Location: Eight at Gazegill Gazegill Organics Dancer Lane Rimington BB7 4EE
Proposal: Retrospective planning application to continue use of single storey restaurant building, outdoor seating area, play area and vehicle parking area.
Grid Ref: 382097 446306

Further to our original comments dated 12th March 2026 we have reviewed the further submitted information including 'Gazegill – Highways Response and Clarification Note (including Decision Support Note)' and 'Survey and proposed changes' drawings dated 20 April 2026.

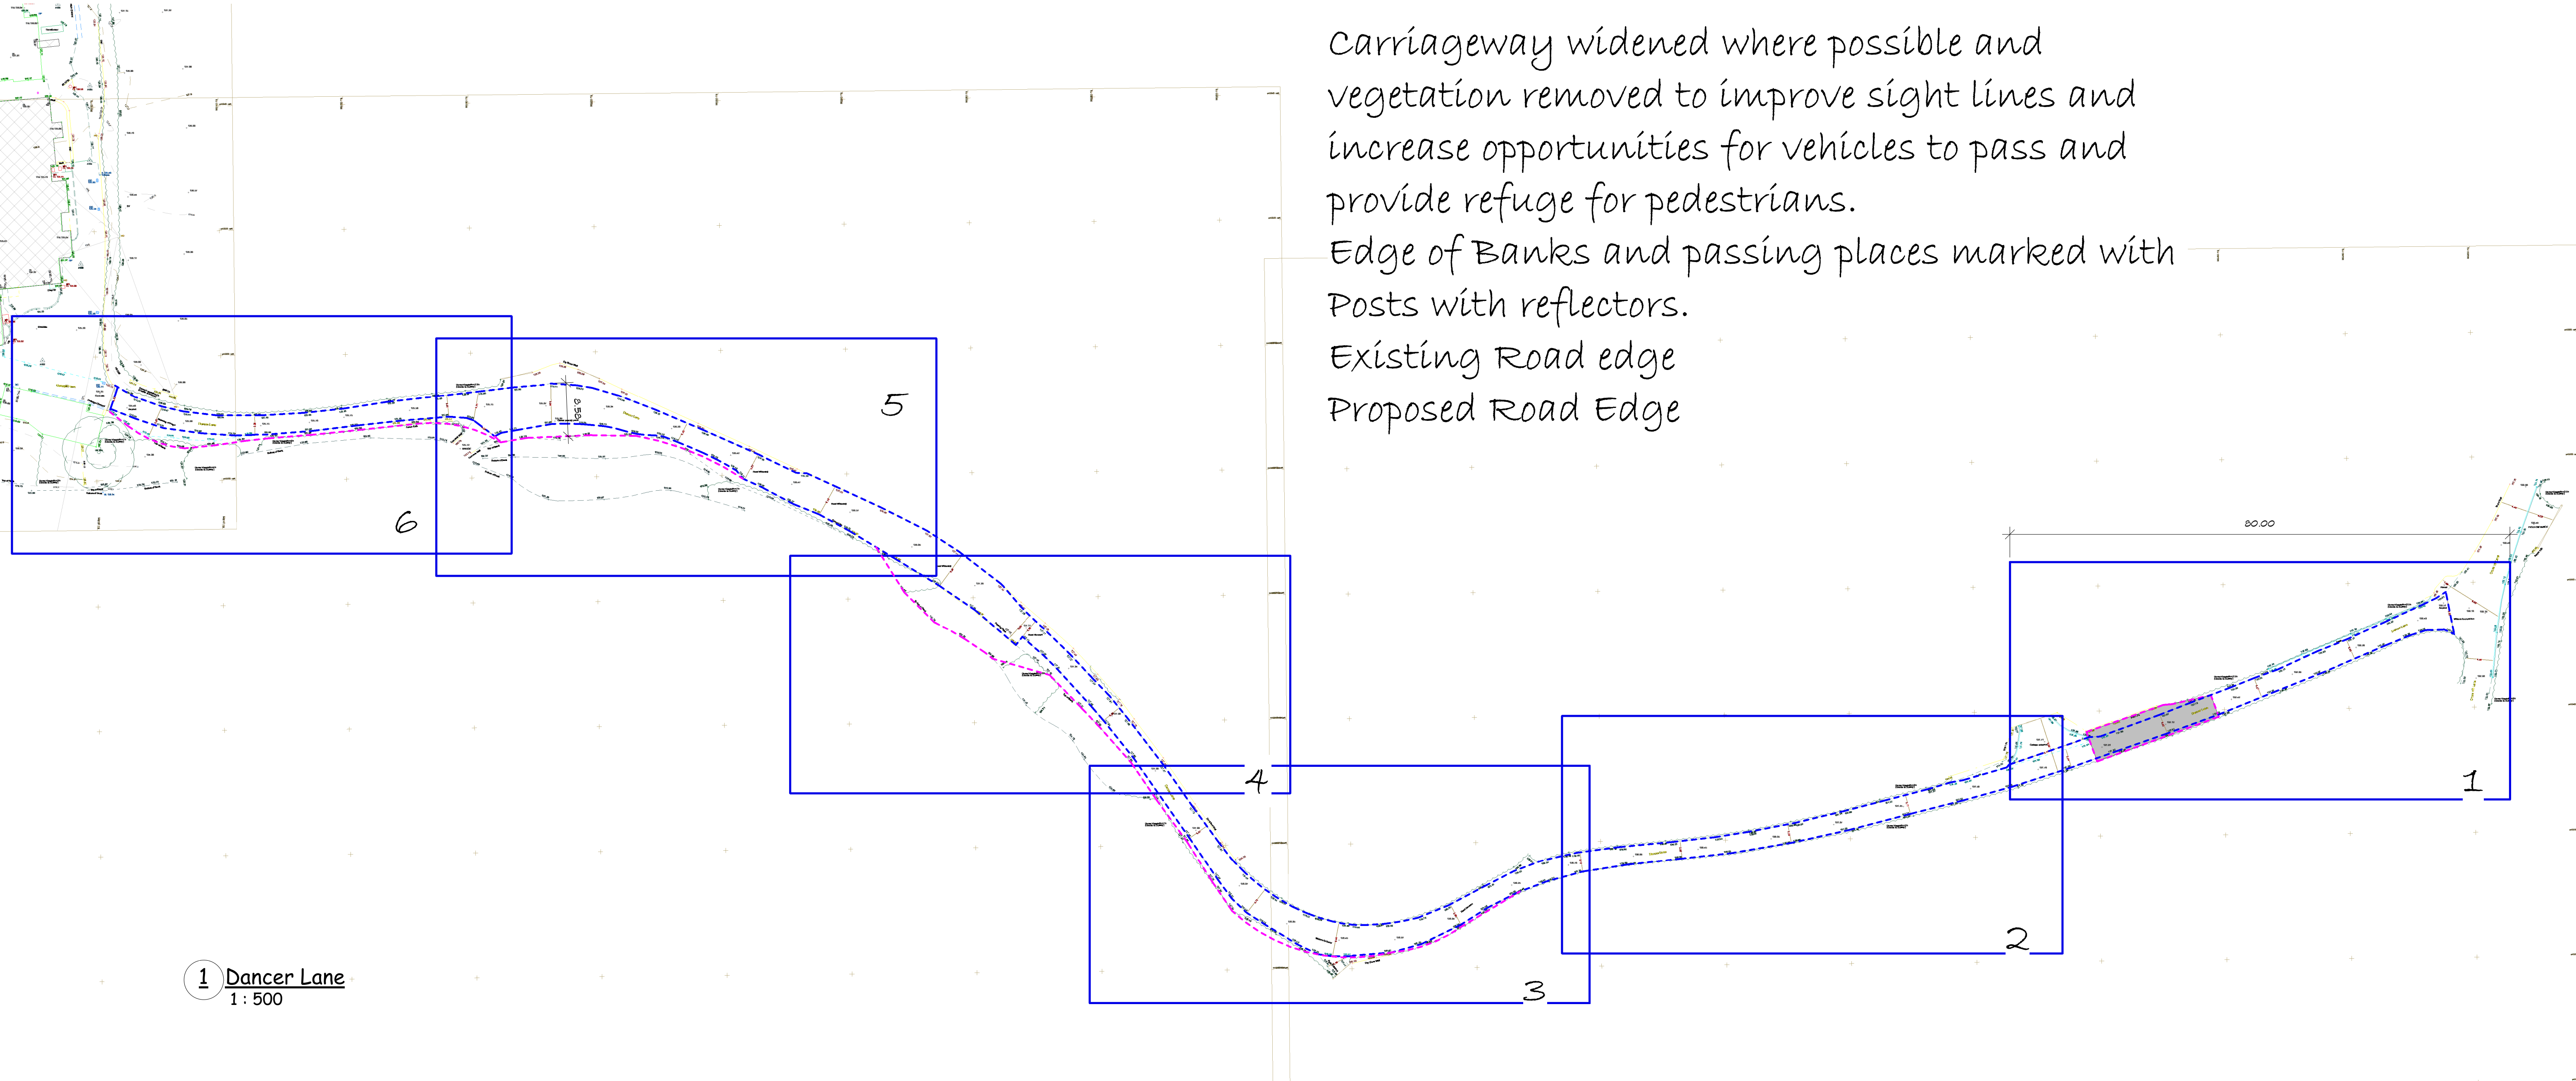
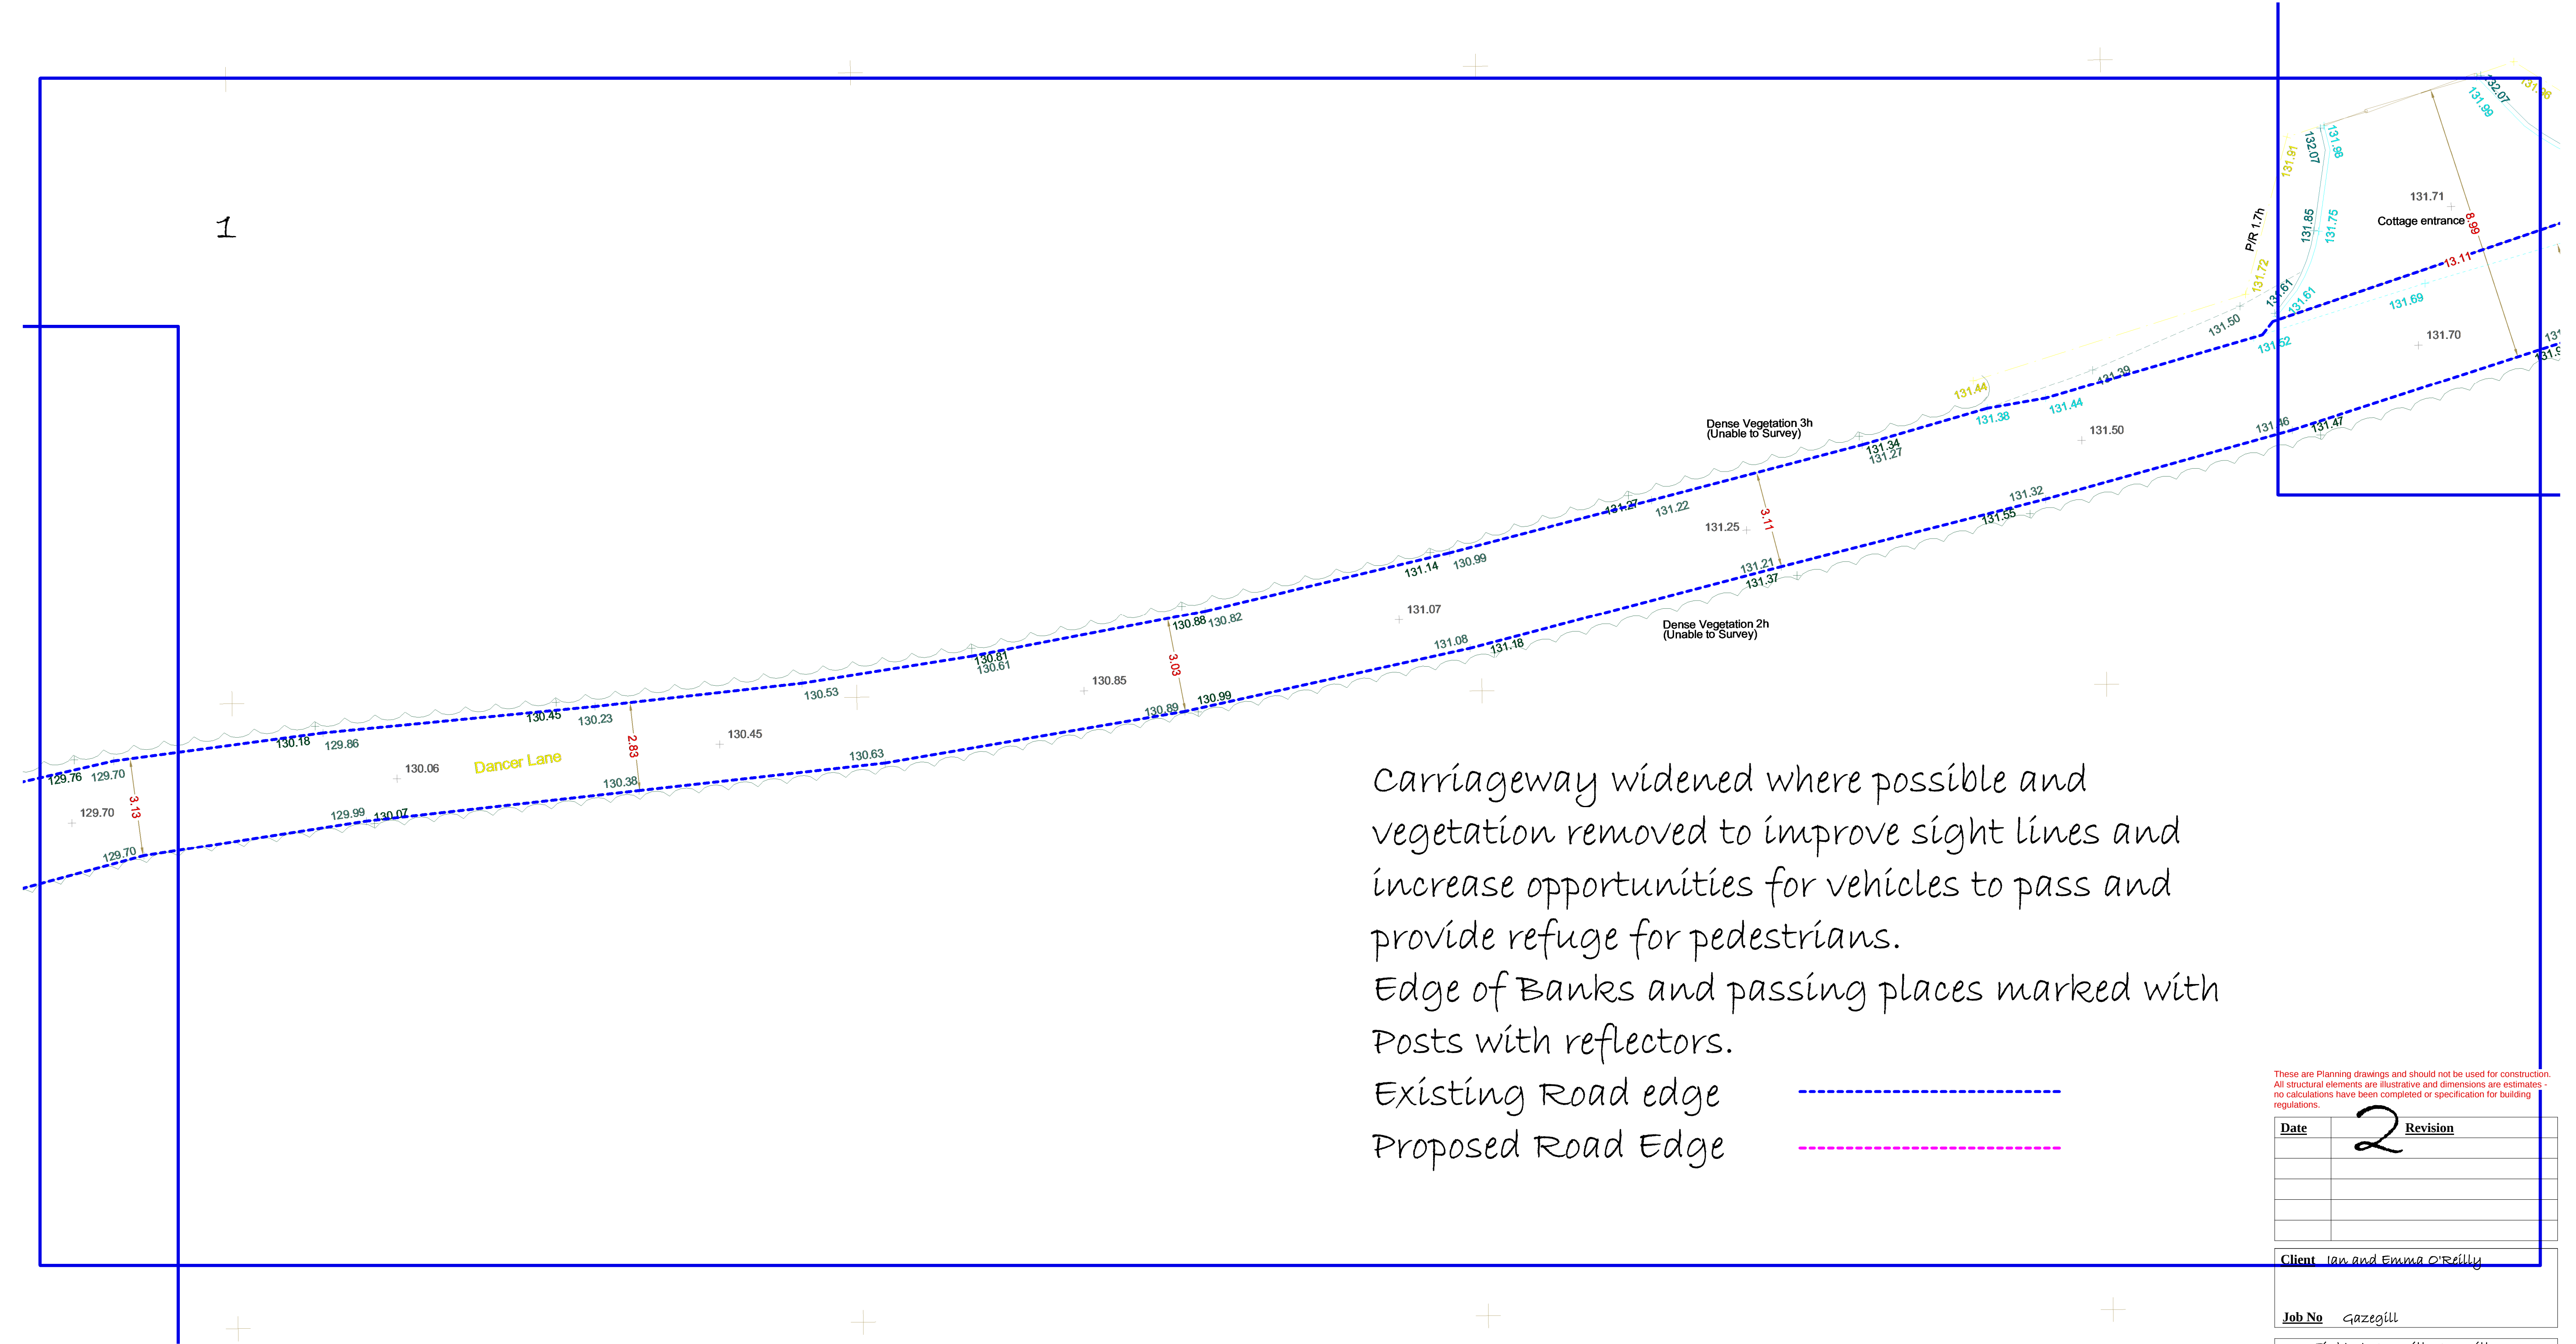
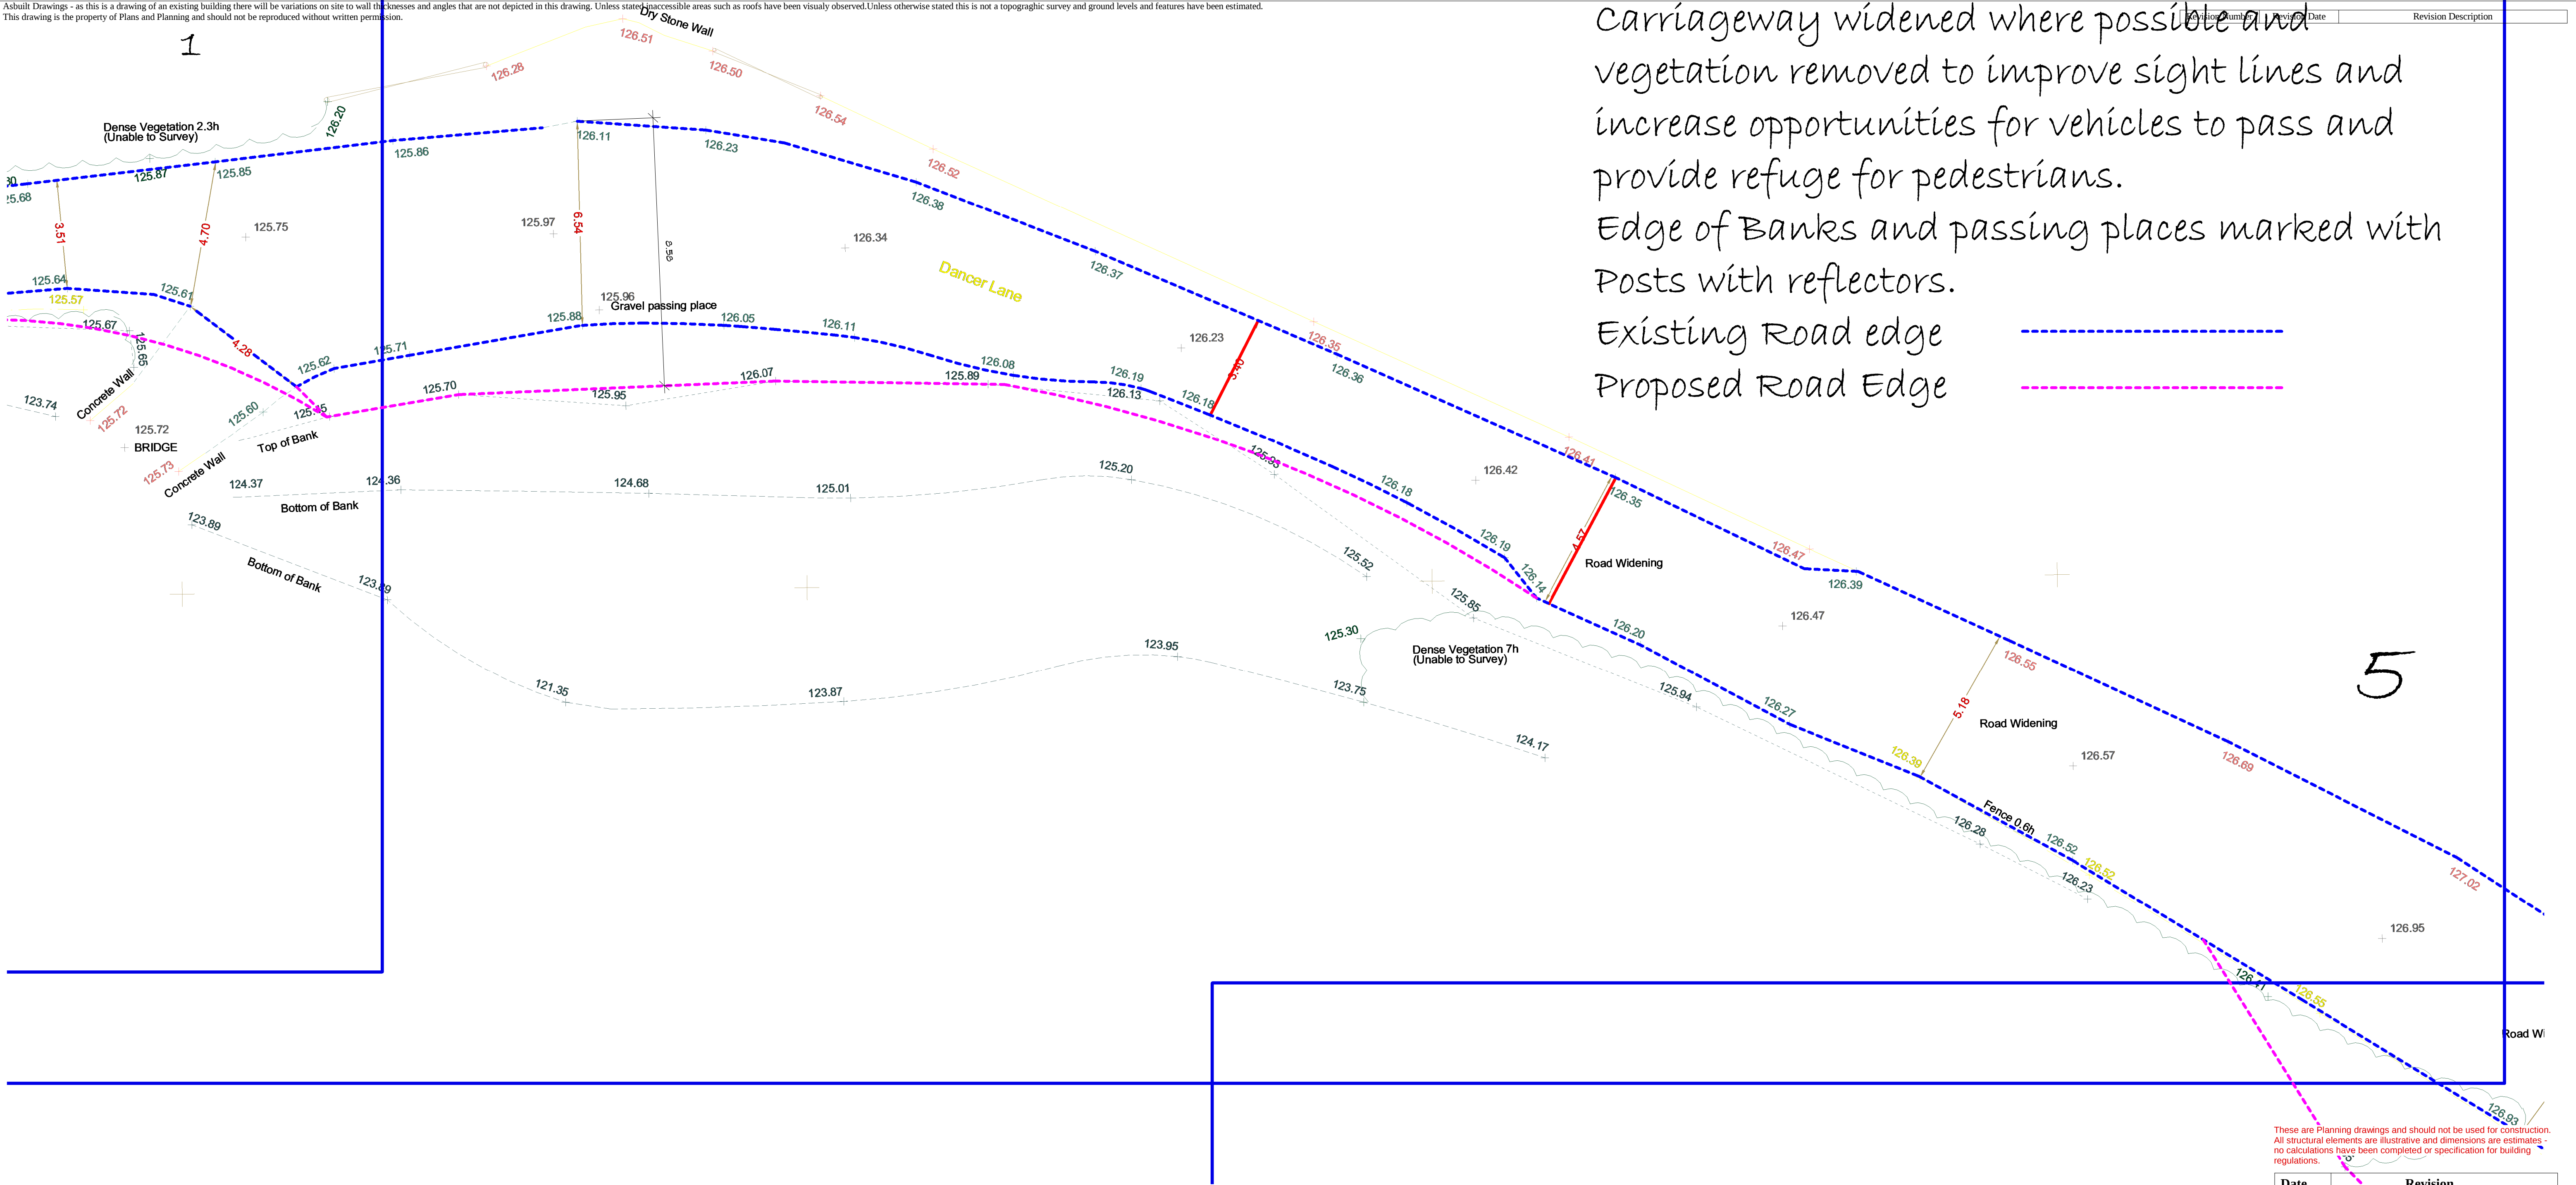
Drawings are submitted to show to Dancer Lane improvements in response to our previous concerns.

The Local Highway Authority have raised concerns over the intensification of use of Dancer Lane previously, in response to applications 3/2018/0700, 3/2016/1159 and 3/2024/0213. Dancer Lane which is a privately maintained single-track road, limited forward visibility in sections, the applicant proposes to make improvements to Dancer Lane to mitigate the concerns regarding footpath users and unprotected drops adjacent to the carriageway.

We note that the application is retrospective and is already operating and that the existing access constraints will likely restrict the site from further intensifying. We would highlight that our concerns regarding this application are sufficiently mitigated to allow us to raise no objection to the application however we still have concerns regarding any further intensification at the site and we place responsibility on the developer to ensure the mitigation measures on Dancer Lane are in place and maintained to allow customers to access the site safely and without detrimental impact upon highway users.

1. The scheme of improvements on approved drawings 'Regularisation of restaurant and car park' Drawings P103 - P103.6 (7 drawings) shall be implemented and maintained thereafter for as long as the development hereby approved is trading.
Reason: For highway safety.
2. The car park shall be provided and maintained for the development hereby approved.
Reason: To ensure adequate car parking provision.
